Planning Officer: Miss Z Toppin

Planning Application Ref: AW/315/20/T

Location: 28A Kingsway, Aldwick, PO21 4DH

Description of works: Fell 1no. oak (T1) to ground level as being suppressed by neighbouring maple (T2) and holly (T3). Fell 1no. Norway maple (T2) to ground level as being suppressed by (T1) and (T2) Fell 1no. holly (T3) to ground level as growing into (T1) and (T2) and as a group of trees making the garden look messy and overcrowded. Fell 3no. Pittosporum (T4) to ground level as structural issues within the tree are showing and as a group of shrubs they are getting overgrown. Replanting in the zones of (T1,2&3) 1No. 2.5-3m English oak. also replanting in the zones of (T4) 2No. 2.5-3m silver birch and 2No. 2.5-3m beech

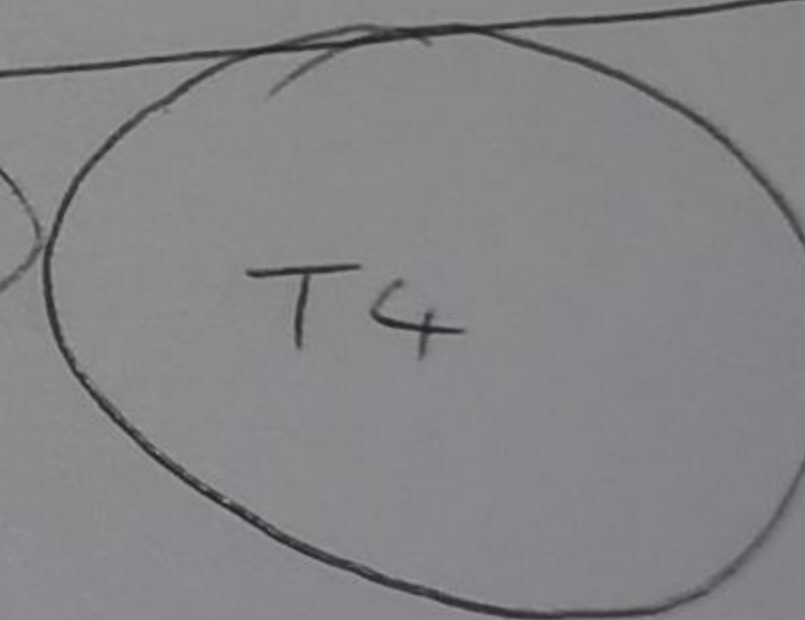
- Once trees T2 and T4 have been felled (and either grubbed or ground out) then replacement trees are to be planted in the same place or nearby and to within 3metres, as shown on the embedded plan (Fig.1).

Silver birch *Betula pendula*, as replacement for T2

Pedunculate oak *Quercus robur*, as replacement for T4
